Sea Link Energy Cable

**Appendix D7 to the Natural England Deadline 7 Submission  
Natural England's Marine Physical Environment Advice**

Planning Inspectorate Reference EN020026

29<sup>th</sup> April 2026

Plate 2.7 Model results for deposition over 7-day period

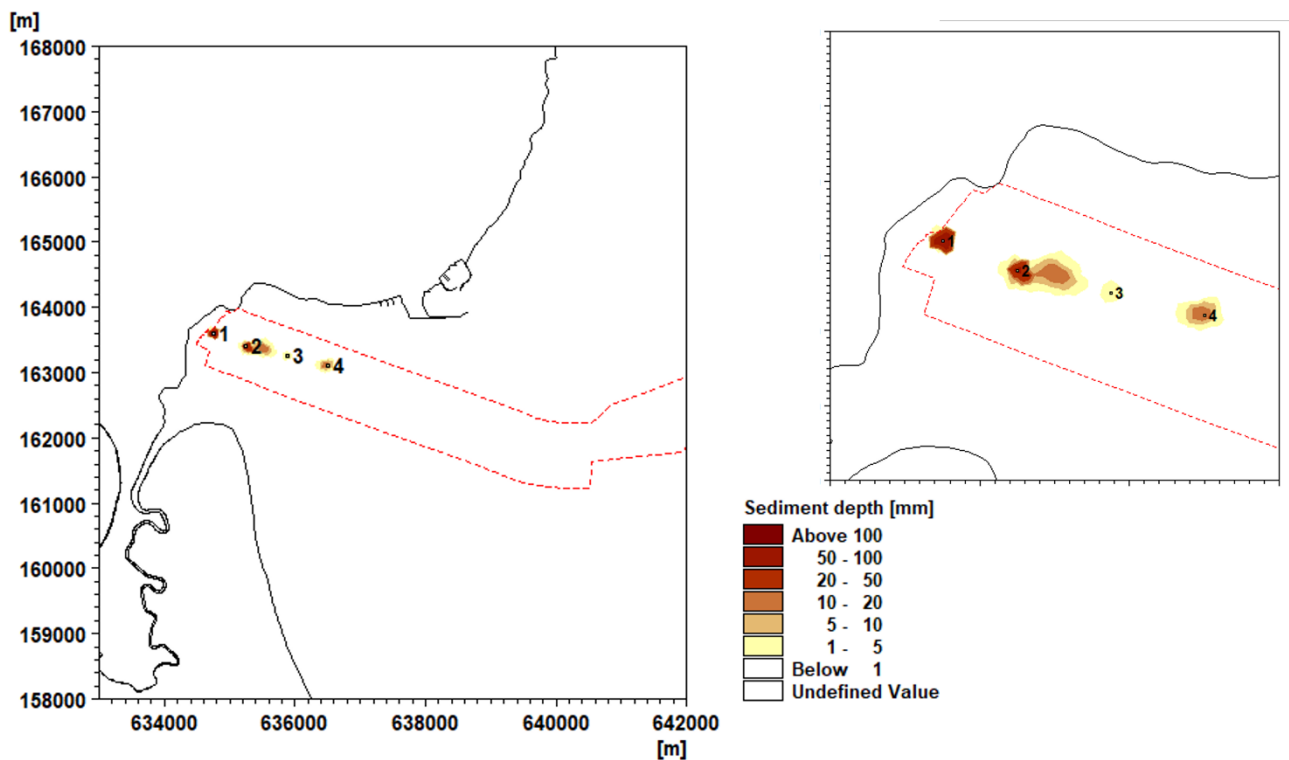
<p>max sediment deposition occurs at Point 1 (90mm), Point 2 (65mm), Point 3 (20mm), and Point 4 (10mm). Although model results in Plate 2.7, appear to show a sediment deposition thickness of &gt;100mm at Point 1 closest to the saltmarsh edge, reducing across the intertidal to 10-20mm at the lowest point, Point 4.</p> <p>The new model results inform understanding of the WCS sediment deposition thickness due to construction-related activities at Pegwell Bay, although, it is not stated if this represents the overall WCS for any overlapping, additive, cable installation activities. The overall WCS sediment deposition parameters, footprint, thickness and persistence have not been derived, based on the model output for discrete points across the intertidal. However, this would increase understanding of the WCS changes to intertidal mud/sandflat morphology and elevation.</p>	<p>we can advise further on the significance of the impacts.</p>

Plate 2.8 Time-series of sediment parameters and water levels over 7-day period

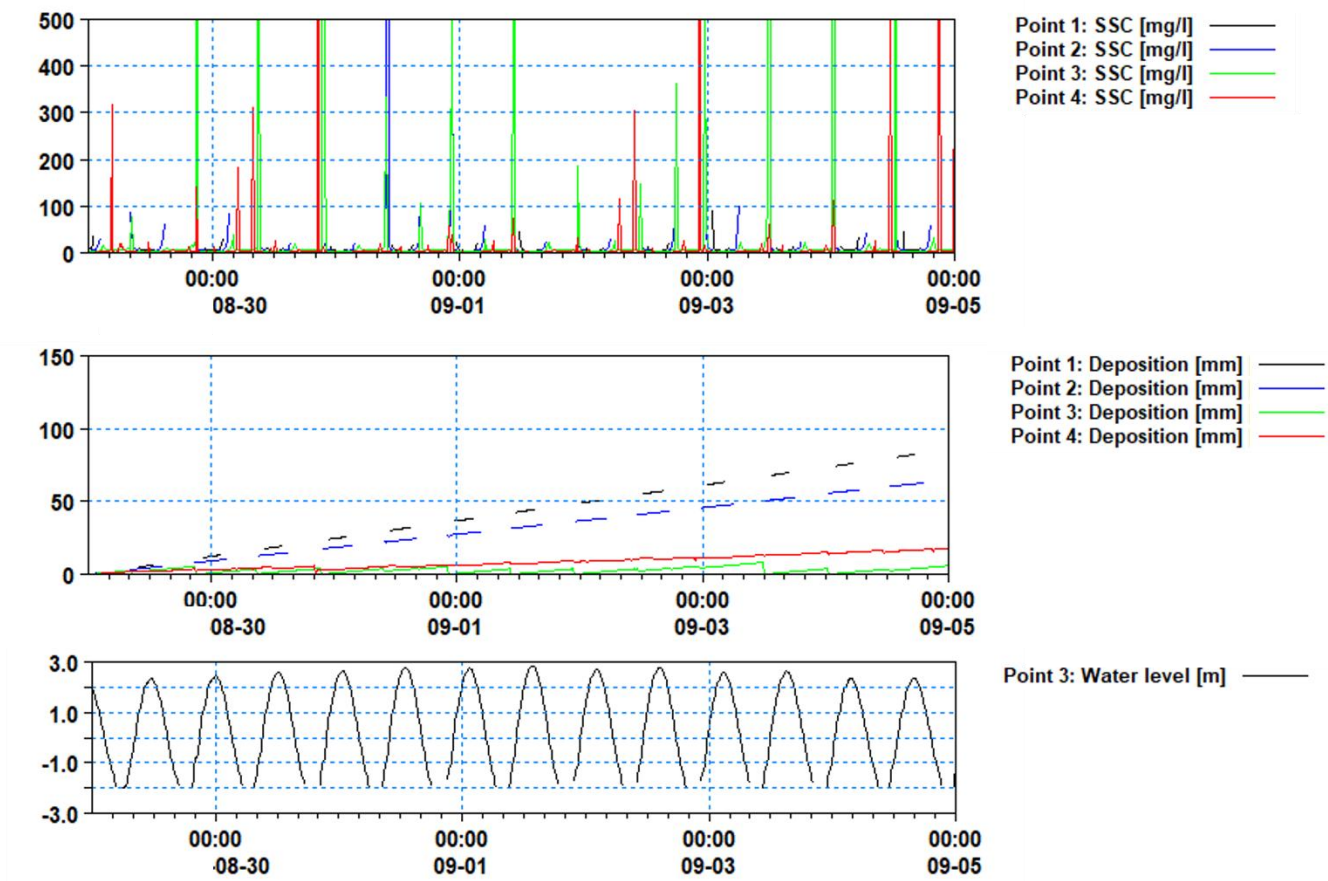
4	Section 3.2	Natural England notes that trends in deposition associated with sediment disturbance at Pegwell Bay are discussed, but not maximum deposition values for the four release points across the intertidal. However, Plate 2.8 shows a continuous trend of increasing deposition thickness across the intertidal with distance from the saltmarsh, over the 7-day period modelled. For example,	We advise that the WCS parameters should be provided for construction-related changes in intertidal mud/sandflat morphology and elevation due to sediment deposition (i.e. deposition thickness, extent, and persistence) before

Plate 2.9 Changes in current speed around cofferdam

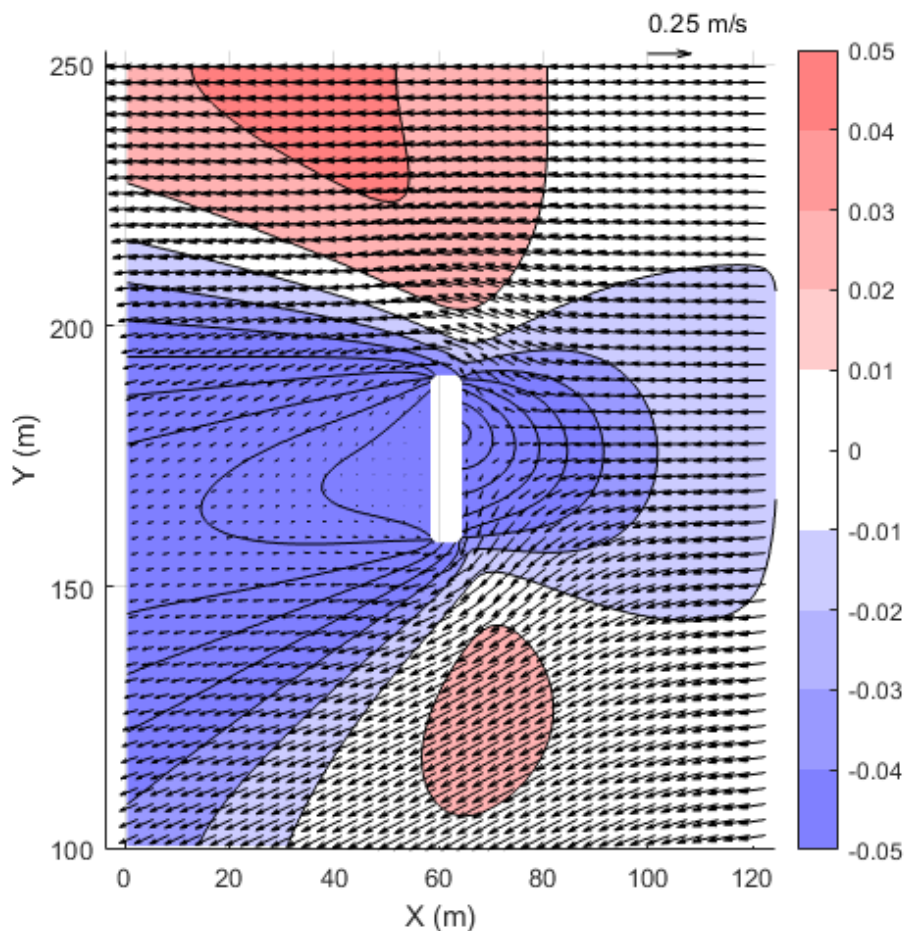
3	Section 2.3	Natural England welcomes the additional modelling of cofferdam blockage effects at Pegwell Bay. We note that the modelling shows that the increase in current speed due to the presence of a cofferdam is not sufficient to cause erosion of saltmarsh sediments, which is welcomed.  However, we advise that monitoring should be undertaken to support the EIA conclusions and demonstrate that there are no unexpected changes to the saltmarsh sediments.	We welcome assurance that the presence of the cofferdams during construction at the Kent landfall will not cause erosion of saltmarsh sediments. However, we advise that the model assessment conclusions should be verified through monitoring. Therefore, we advise that the proposed Kent landfall monitoring should include a commitment to validate ES predictions regarding impacts on the nearshore and saltmarsh due to the presence of cofferdams. If appropriate monitoring can be secured, then we will likely consider this issue resolved.
